KIRKLEES METROPOLITAN COUNCIL INVESTMENT & REGENERATION SERVICE

DELEGATED DECISION TO DETERMINE PLANNING APPLICATIONS

Reference No:	2022/62/93583/W
Site Address:	8, Dryclough Avenue, Crosland Moor, Huddersfield, HD4 5JU
Description:	Erection of single storey extensions and alterations to bungalow
Recommending Officer:	Luke Walstow

OFFICER REPORT

Ground Floor Plan  
1 : 100

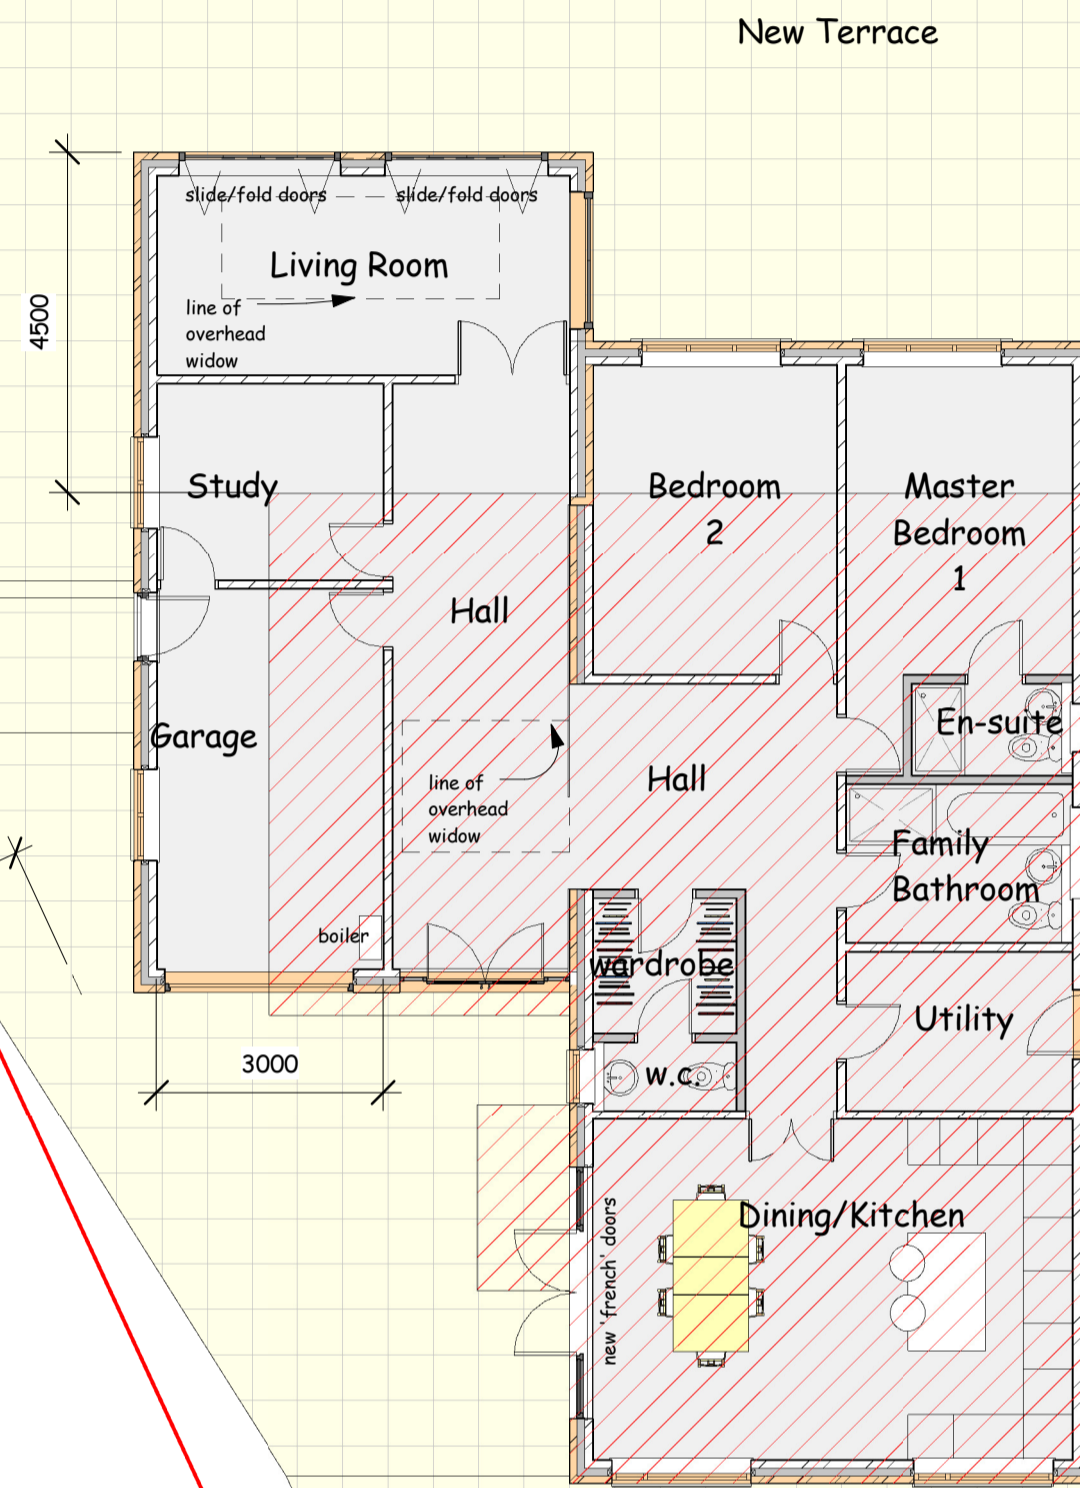
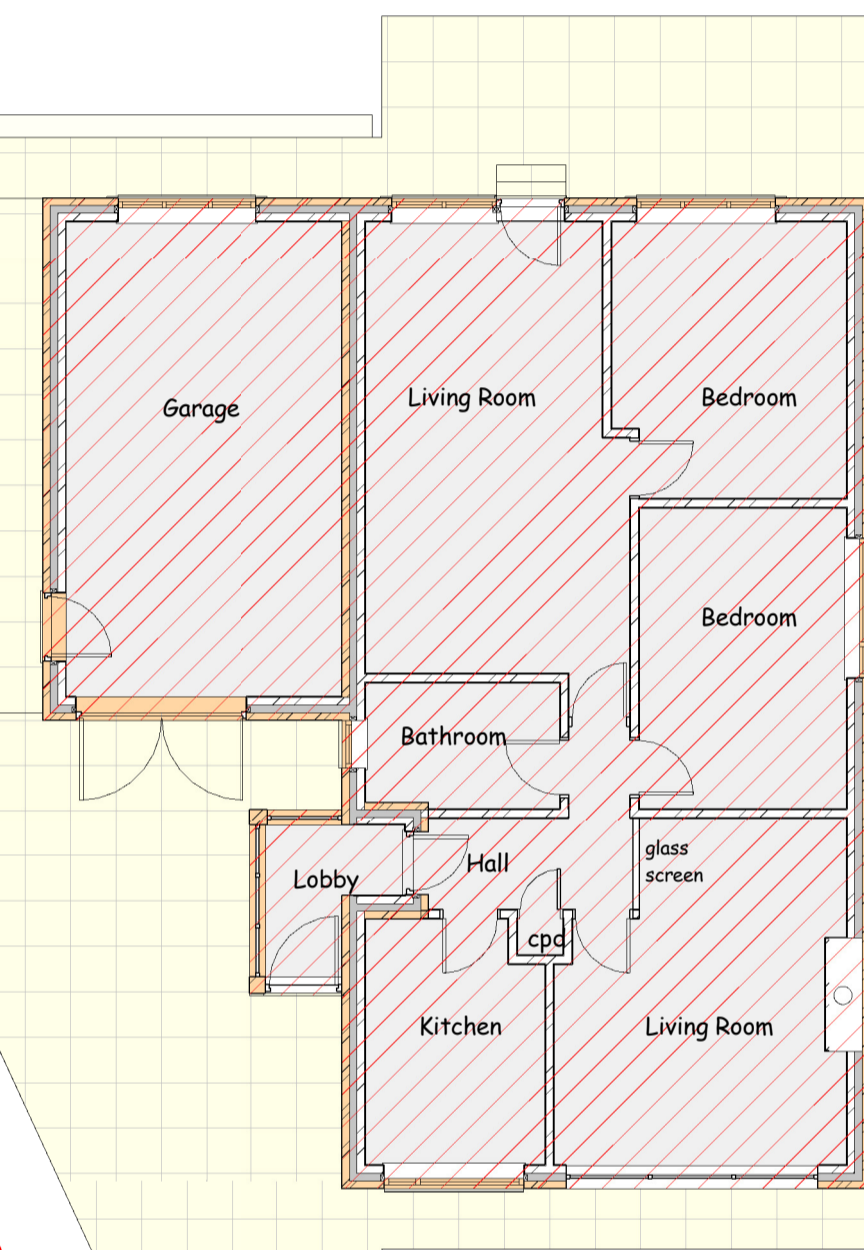
Plans were sought from the agent to reduce the scale of the development, as it was deemed overdevelopment of the site. Officers asked for the rear extension

to be brought back to 4 metres in projection and the side extension to measure 1.8 metres which would reduce the overall size of the extended dwelling. Plans submitted on 2 October 2023 are considered to be acceptable.

A further single storey rear extension would extend out from the original building to accommodate a new living room, hallway, and study area. The rear extension would add a 4.5-metre projection to the original building. Although this projection is not SPD compliant, the large rear outdoor space allows the extension not to be cramped and the 0.5 extra over guidance would not result in overdevelopment of the site or material harm to visual amenity. The rear extension would be constructed from materials which match the original dwelling and would be good in design. There would be roof lights inserted in the roof over the living room to provide natural light. The rear wall will consist of glazed panels which look onto the large rear garden. The rear extensions can be accepted by officers as the rear extensions are of good design and would project onto a large rear garden ensuring the extensions do not dominate the entirety of the site.

The proposed extension would be constructed from the same materials to maintain a unified appearance for the whole dwelling. The side extension would include a garage, large hallway, a living room and a utility room. Amended plans moved the side extension further off the neighbouring boundary to be more acceptable. Large roof lights are proposed within the side extension. Large windows are proposed to the rear elevation of the side extension, which would project out onto the rear garden. Officers can confirm the side extension is acceptable.
